<b>Location of Construction:</b> 123 BELFORT ST	<b>Owner Name:</b> Mitschele, Peter M.	<b>Owner Address:</b> 240 Woodville Road	<b>Phone:</b>
<b>Business Name:</b>	<b>Contractor Name:</b> Home owner	<b>Contractor Address:</b>	<b>Phone</b>
<b>Lessee/Buyer's Name</b>	<b>Phone:</b>	<b>Permit Type:</b> Additions - Dwellings	<b>Zone:</b>

<b>Dept:</b> Zoning	<b>Status:</b> Approved with Conditions	<b>Reviewer:</b> Ann Machado	<b>Approval Date:</b> 07/26/2006
<b>Note:</b> Front entry porch is OK per section 14-425. It extends from building 6' and 33 s.f. is in the front yard.			<b>Ok to Issue:</b> <input checked="" type="checkbox"/>
1) This property shall remain a single family dwelling. Any change of use shall require a separate permit application for review and approval.			
2) This permit is being approved on the basis of plans submitted. Any deviations shall require a separate approval before starting that work.			
<b>Dept:</b> Building	<b>Status:</b> Approved	<b>Reviewer:</b> Tammy Munson	<b>Approval Date:</b> 08/14/2006
<b>Note:</b>			<b>Ok to Issue:</b> <input checked="" type="checkbox"/>

123 Belfort Street INSPECTION DATE: June 1, 2006
Portland, Maine SCALE: 1" = 20'

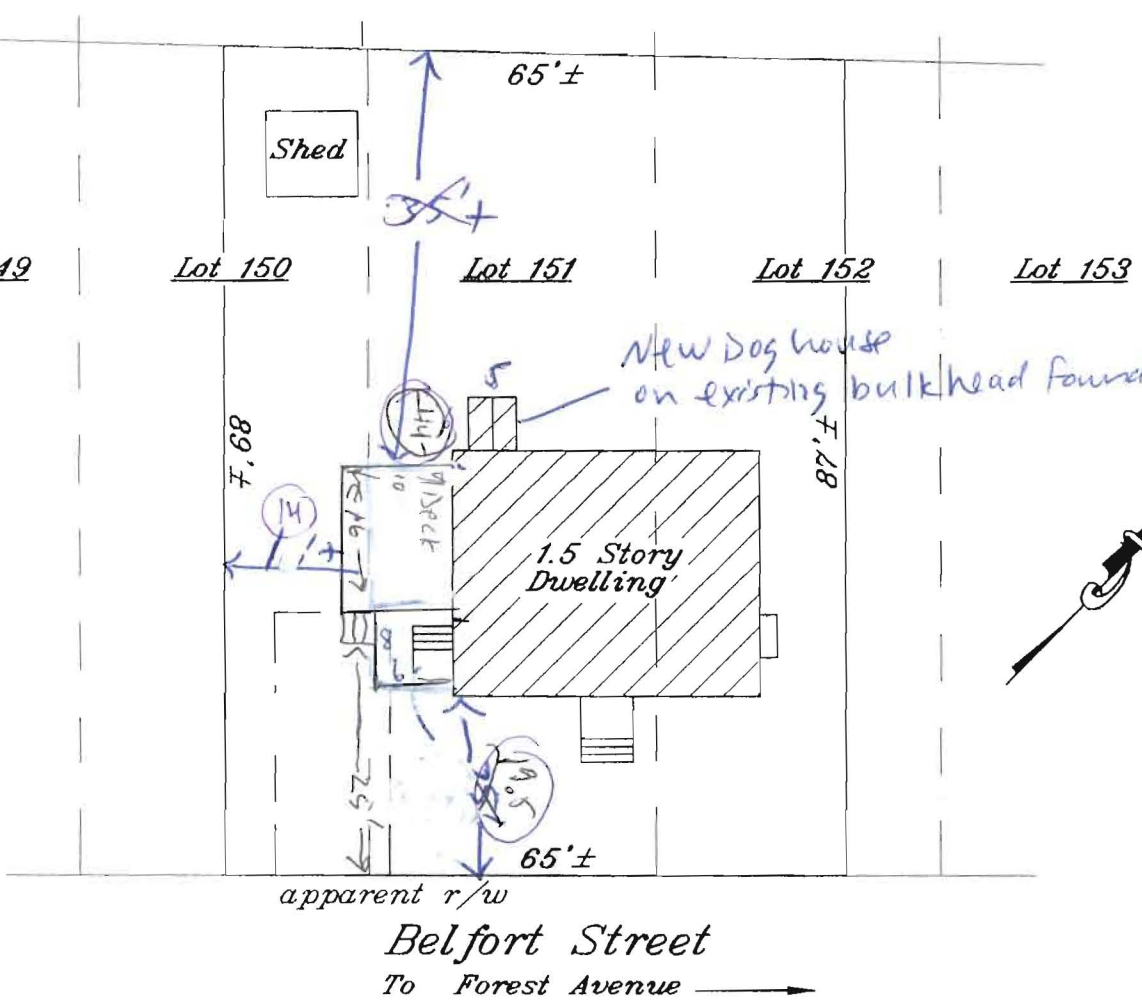
**Comments:**  
7/24/06-amachado: Spoke to Peter Mitschele. He needs to confirm the front setback because the MLIP scales at 19' to the front property line and he needs 25' for the R3. He said that he would get back to me. He said tha the corner of the house is 37' from the street.  
7/24/06-amachado: Spoke to Peter again. He measured to the front property line from the rear pin and the house is about 20' from the front property line. He will come in and revise the permit to put an entry way on that meets section 14-425.  
7/26/06-amachado: Peter revised the permit so it meets the setbacks.
